Application ref: BR/131/20/PL

JJR DESIGNS Limited

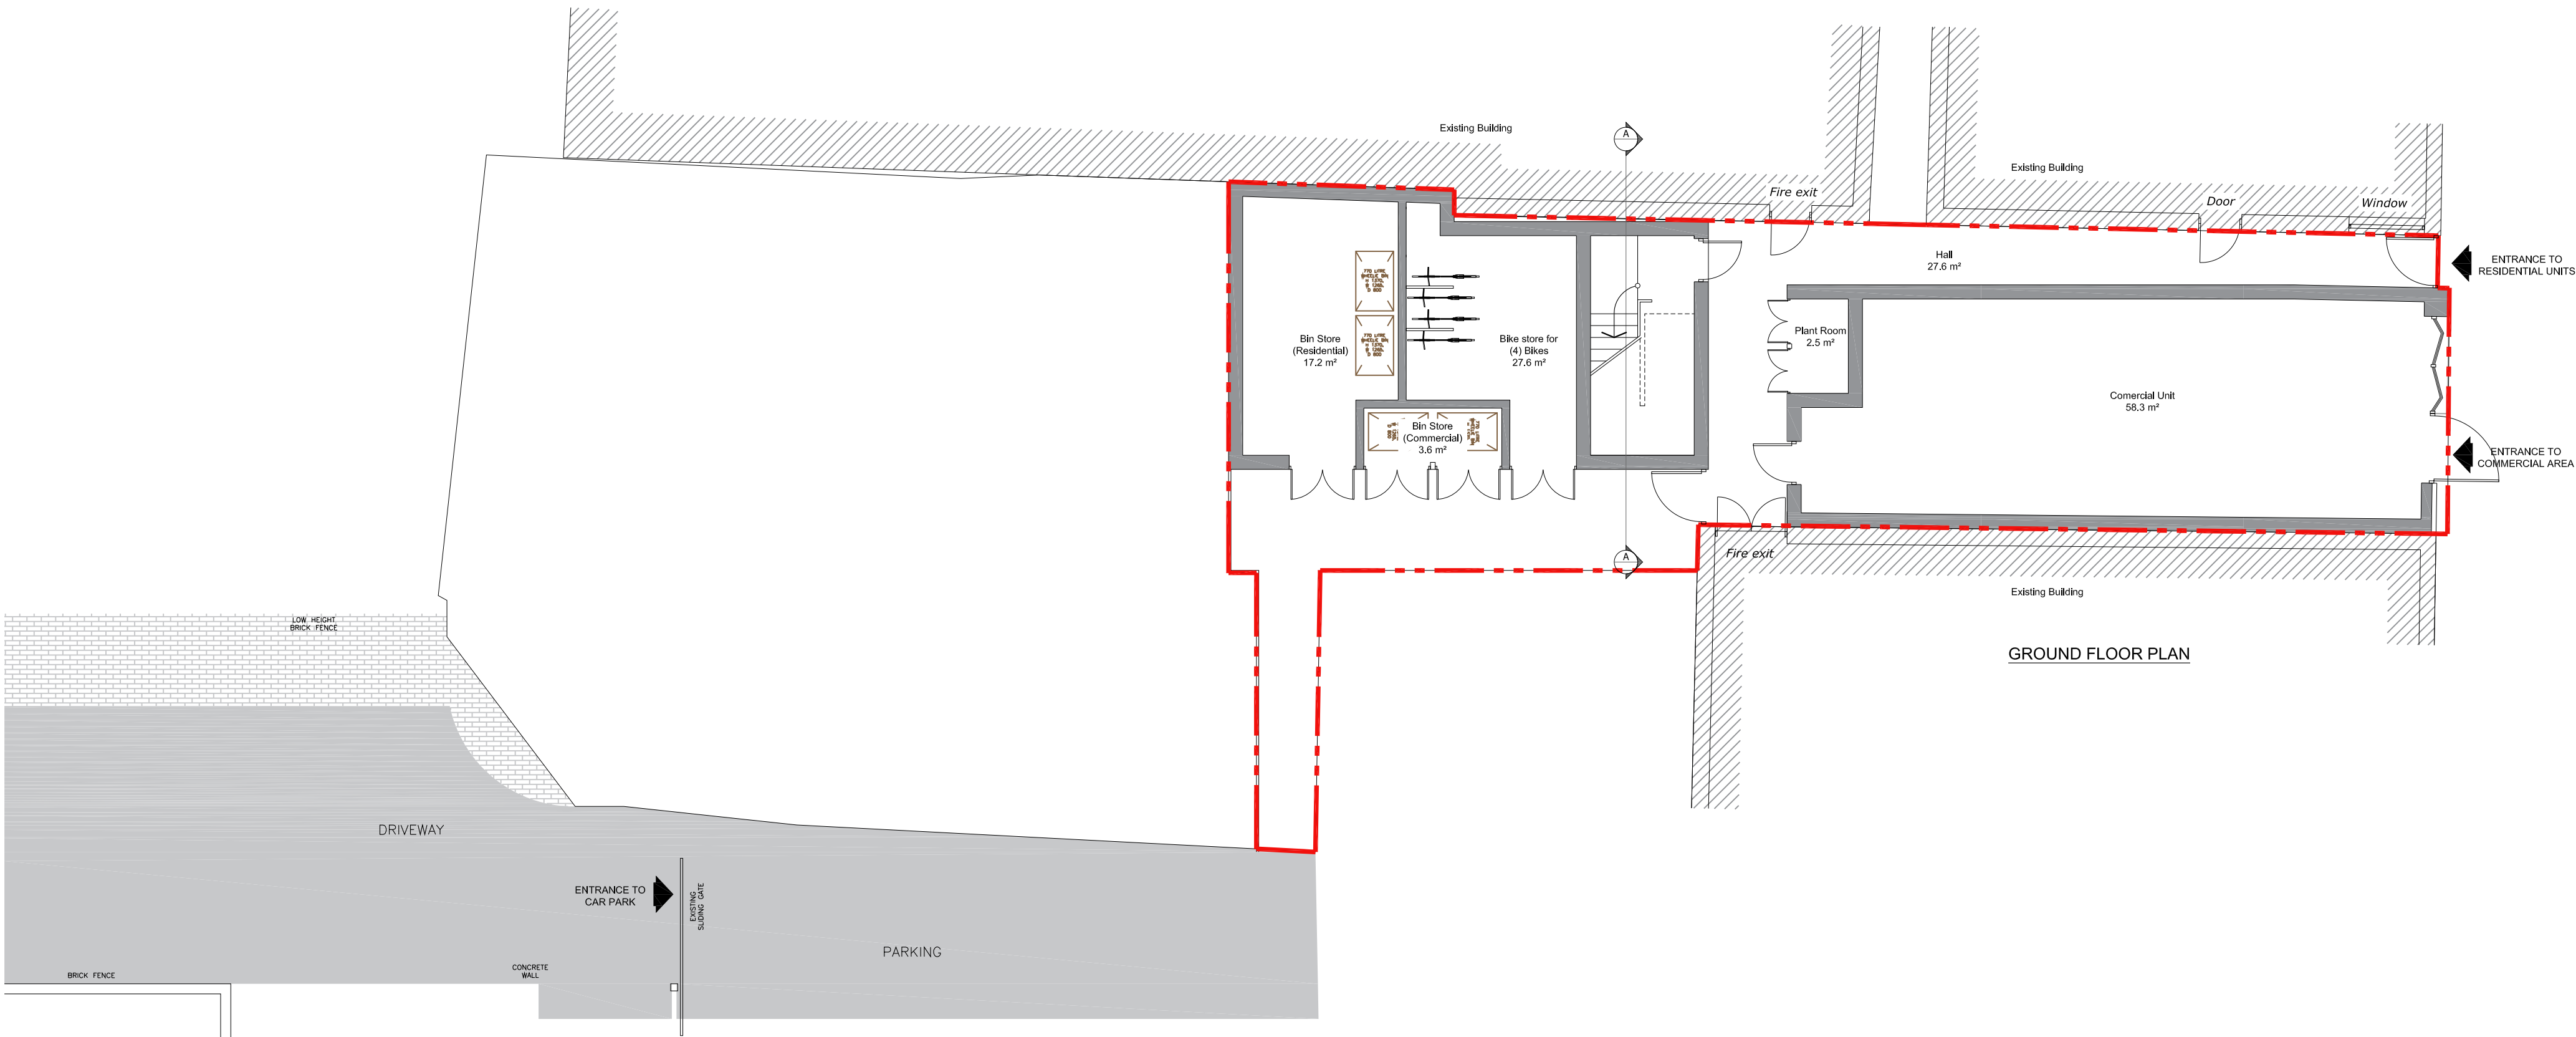
I act on behalf of Santander bank who occupy no. 42 High Street, Bognor Regis. Santander use the roadway at the rear of their branch as a fire escape and bin store. The above application proposes to build onto this roadway and thereby block Santander's emergency escape route. I object to this planning application on safety grounds and I urge the Council to reject it.
